From: Edward Saulig <ESaulig@fairfieldcity.nsw.gov.au>
Sent: Monday, 19 December 2016 11:24 AM
To: Necola Chisholm
Subject: SSD7917 - Warehouse/Dist Centre, THD/Cowpasture Road - Comments by 16.12.2016

From: Nicoleta Diacopoulos
Sent: Friday, 16 December 2016 1:17 PM
To: Edward Saulig
Subject: RE: Referral - SSD7917 - Warehouse/Dist Centre, THD/Cowpasture Road - Comments by 16.12.2016

- Civil Design Report
- Plan 16875_DA_C100_01 General Arrangement
- Plan 16875_DA_C101_01 Sheet 1/4
- Plan 16875_DA_C102_01 Sheet 2/4
- Plan 16875_DA_C103_01 Sheet 3/4

GENERAL ARRANGEMENT PLAN

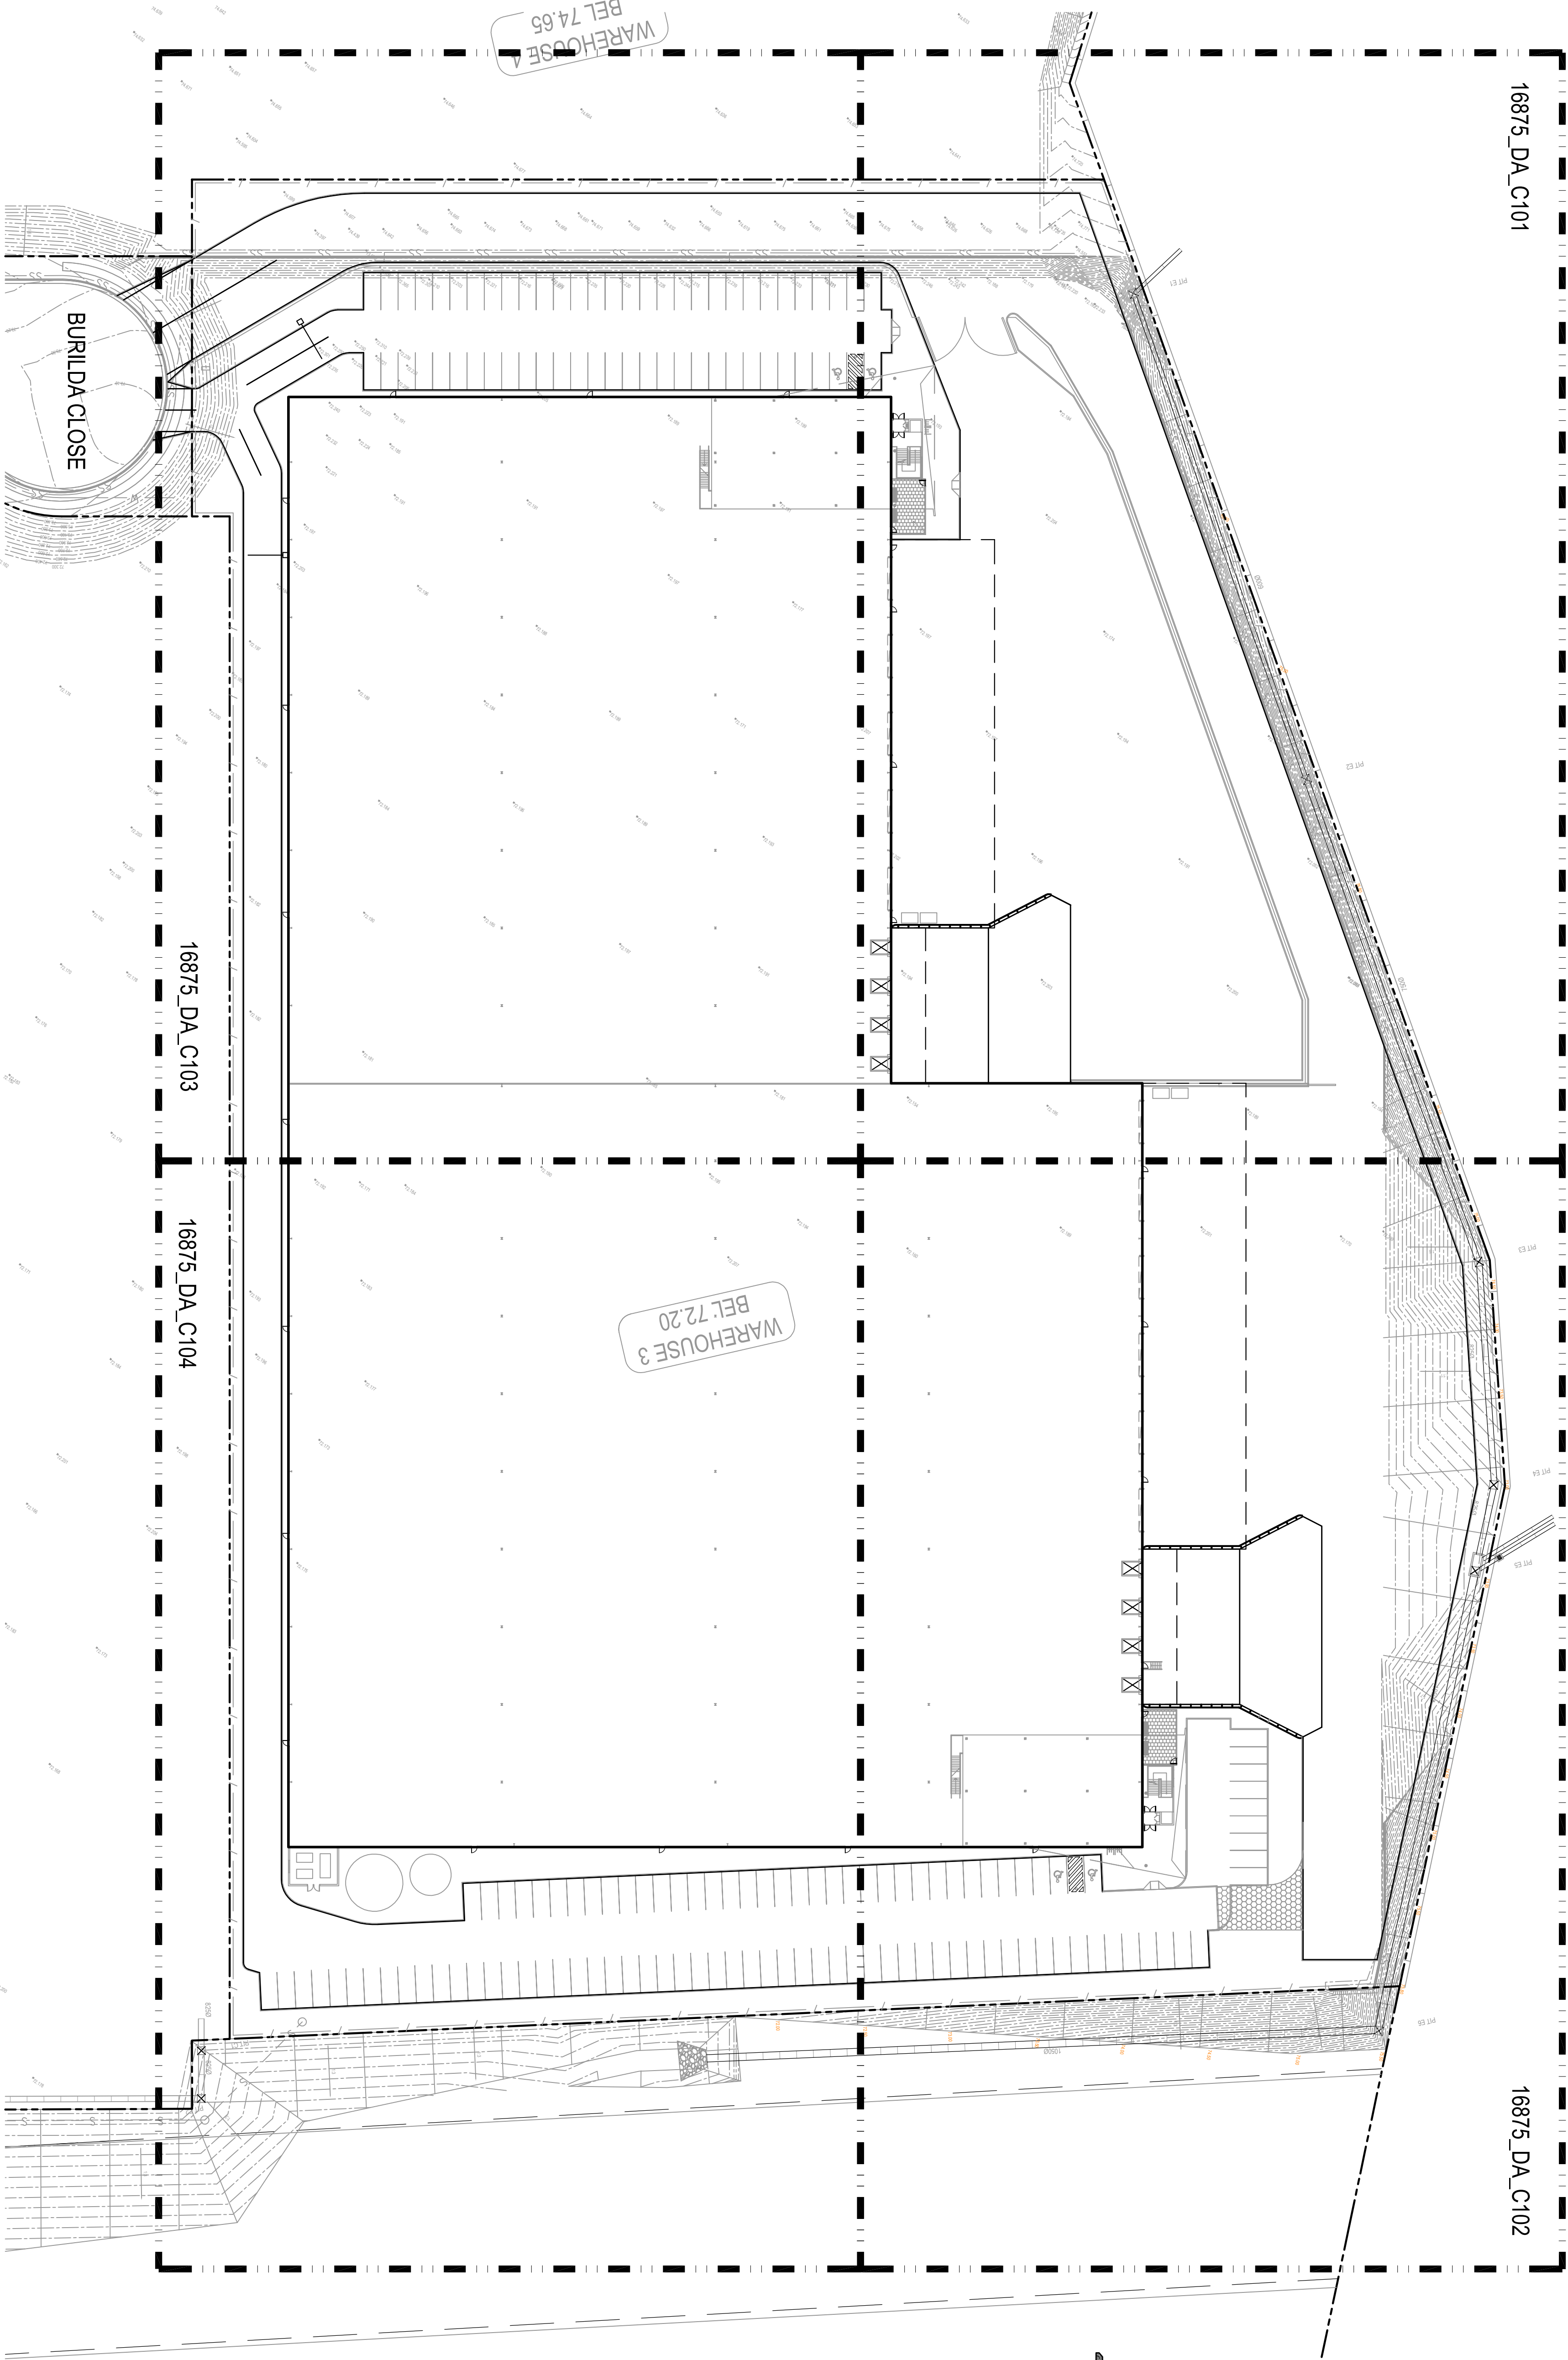
It is proposed to discharge the site drainage to the existing and approved connection point located at the North East corner of the site. The stormwater is then directed to the existing Detention and Water Quality Basin. The basin was designed to accommodate this site's water quality and detention requirements.

With regard to the internal drainage the civil report advises that the in-ground pipe drainage system has been designed for the entire site, and caters for the 100 Year ARI.

FFL will have a 300mm freeboard above the overland flows.

The external catchments from the West of the site will be diverted by a swale/channel and 750mm pipe and directed to the existing overland flow channel to the north of the site. This was approved as a concept previously and described in section 5.4 (page 14) of the Civil Engineering Report – Horsley Drive Business Park, S96 Application (Rev A December 2014) prepared by Costin Roe.

1. Stormwater Drainage Certificate

Prior to the issue of a Construction Certificate, a certificate from a suitably qualified person shall be submitted to the Certifying Authority certifying that:

- a. Satisfactory arrangements have been made for the disposal of stormwater;
- b. The proposed development and alterations to the natural surface contours will not impede or divert natural surface water runoff so as to cause a nuisance to adjoining properties;
